CITY OF ALBUQUERQUE

June 22, 2020

Re: **Project Name**
601 Mountain Road NW
Traffic Circulation Layout
Architect's Stamp **no date provided**(J14-D195)

Based upon the information provided in your submittal received 06-22-2020, the above referenced plan cannot be approved for Building Permit until the following comments are addressed:

AS100

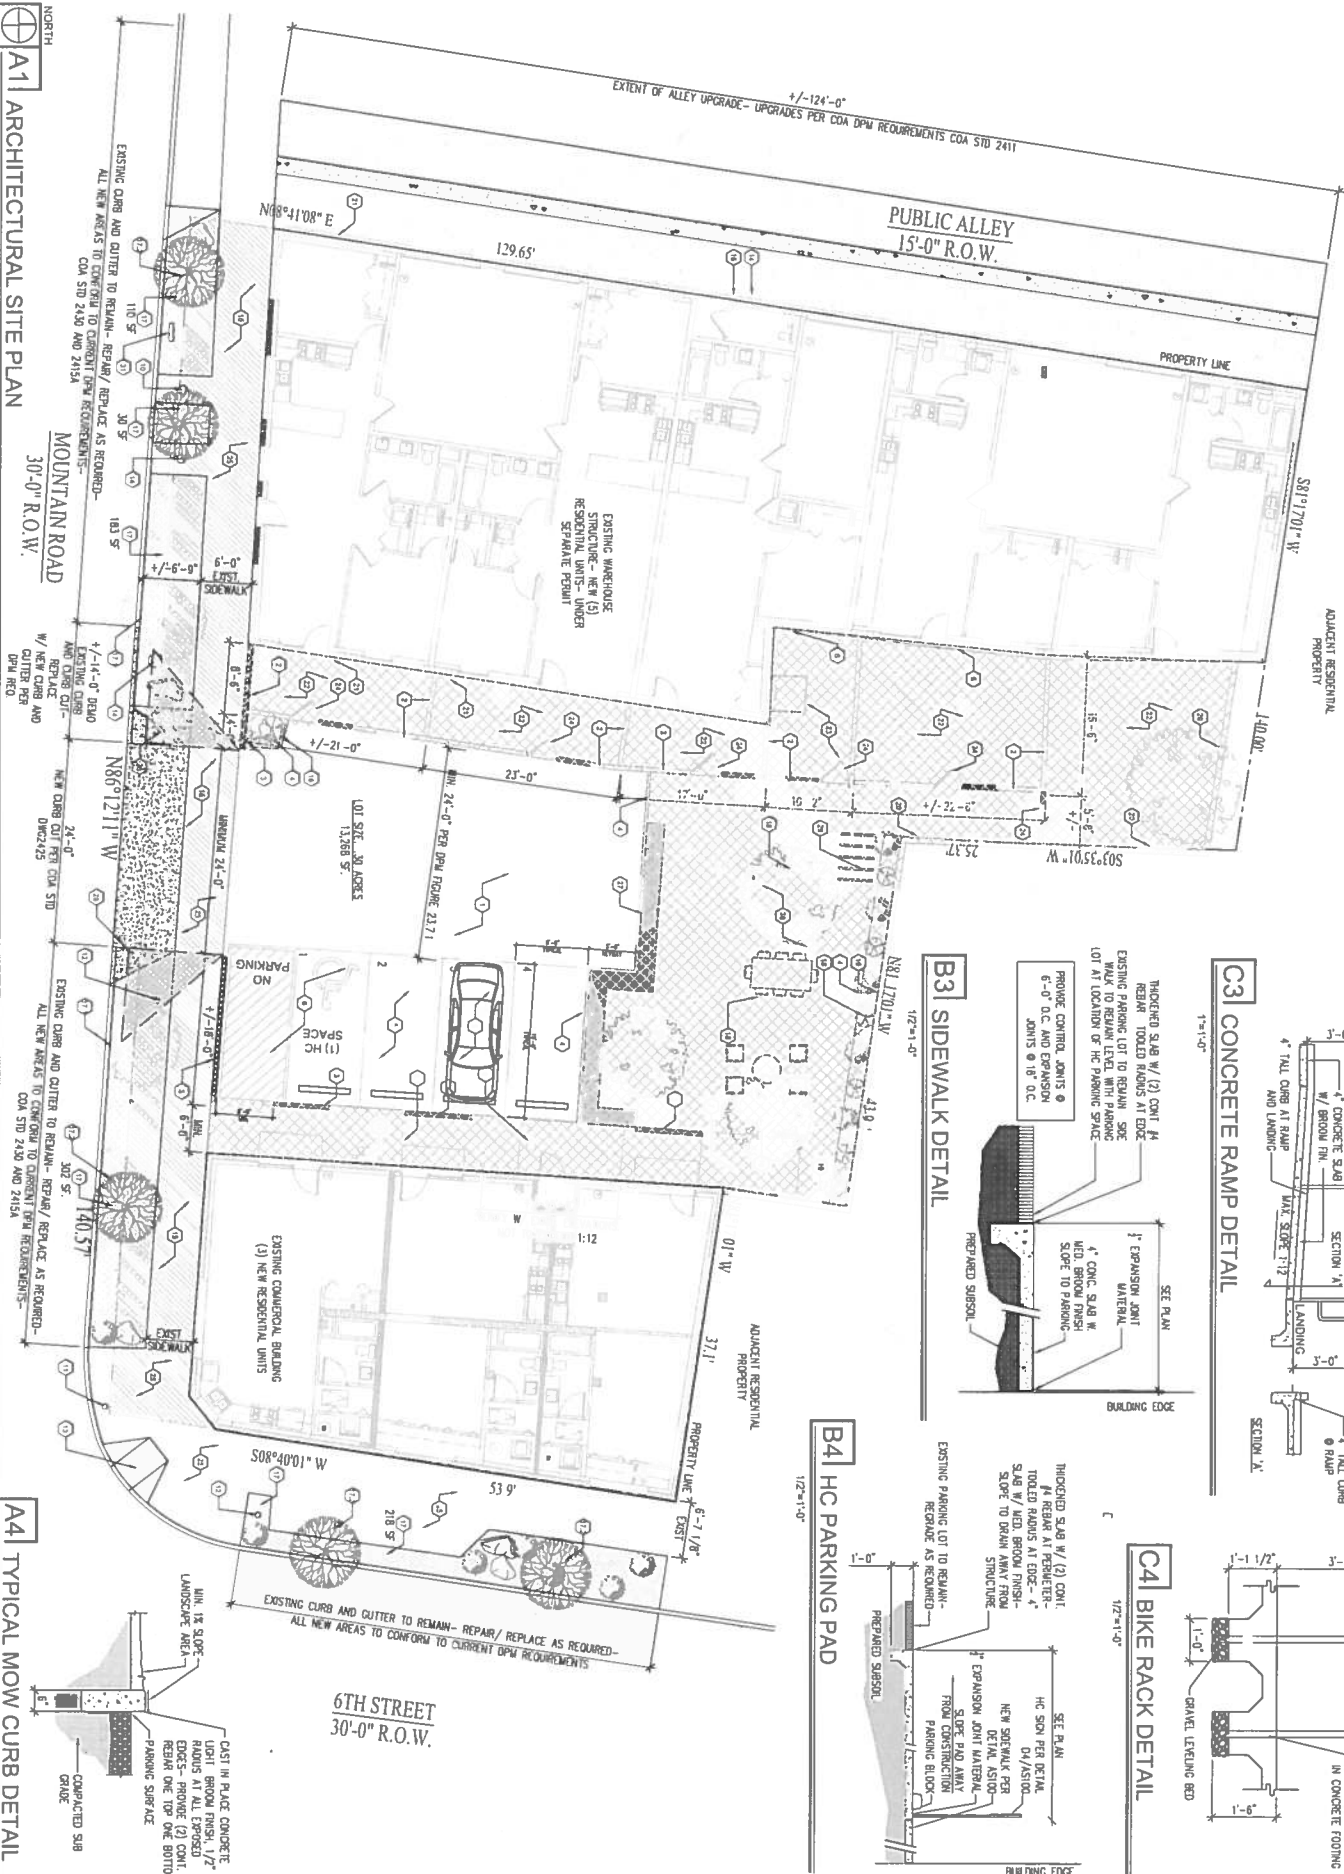
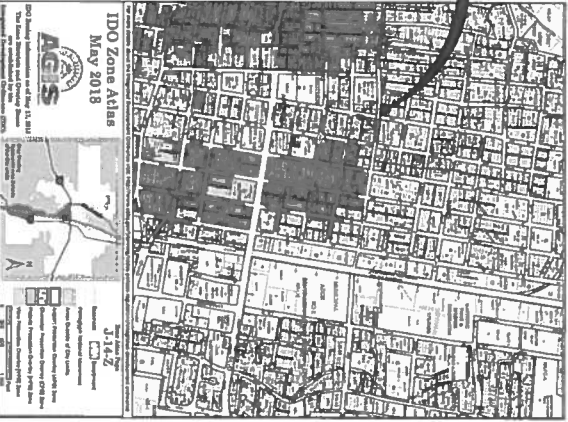
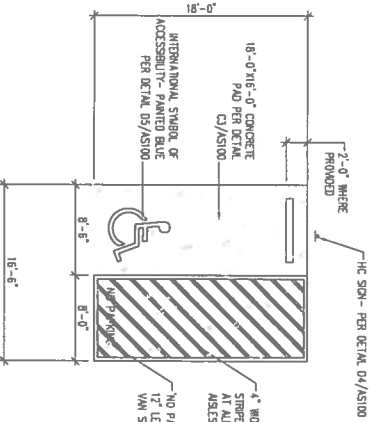
1. The Traffic Circulation layout must be stamped, **dated and signed** by an licensed Architect in the state of New Mexico.
2. Please list the width and length for all existing and proposed parking spaces. Some dimensions are not shown.
3. The minimum parking stall dimensions are:

Type of parking	Min. Width	Min. Length	Min. Overhang
Standard	8.5'	18'	2'
<i>Compact</i>	7.5'	15'	1.5'
Motorcycle	4'	8'	N/A
ADA	8.5'	18'	2'

4. The ADA accessible parking sign must have the required language per 66-7-352.4C NMSA 1978 **"Violators Are Subject to a Fine and/or Towing."** Please call out detail and location of signs.
5. The ADA access aisles shall have the words **"NO PARKING"** in capital letters, each of which shall be at least one foot high and at least two inches wide, placed at the rear of the parking space so as to be close to where an adjacent vehicle's rear tire would be placed. (66-1-4.1.B NMSA 1978)
6. ADA curb ramps must be **updated to current standards** and **have truncated domes installed** at the corner of Mountain and 6th.

7. Motorcycle parking spaces shall be designated by its own conspicuously posted upright sign, either free-standing or wall mounted per the zoning code.

8. All bicycle racks shall be designed according to the following guidelines:
 - a. The rack shall be a minimum 30 inches tall and 18 inches wide.
 - b. The bicycle frame shall be supported horizontally at two or more places. Comb/toaster racks are not allowed.

- c. The rack shall be designed to support the bicycle in an upright position. See the IDO for additional information.
 - d. The rack allows varying bicycle frame sizes and styles to be attached.

- e. The user is not required to lift the bicycle onto the bicycle rack.
 - f. Each bicycle parking space is accessible without moving another bicycle.

9. Bicycle racks shall be sturdy and anchored to a concrete pad.
10. A 1-foot clear zone around the bicycle parking stall shall be provided.
11. Bicycle parking spaces shall be at least 6 feet long and 2 feet wide.

12. A 5 ft. keyway is required for dead-end parking aisles.
13. Please specify the City Standard Drawing Number when applicable. For Drivepad/driveway COA STD DWg 2425.

14. Add a note stating "All broken or cracked sidewalk must be replaced with sidewalk and curb & gutter." A build note must be provided referring to the appropriate City Standard drawing 2430 and 2415A.

15. Any private structures that are located within public right-of-way such as bike racks, building doors, fences and walls shall either be removed or else a revocable permit with the City is required in which an annual fee is paid per year, based on square footage of the encroachment.

16. Provide all reference sheets for proposed details.
17. A copy of the Sidewalk easement/plat will need to be provided.
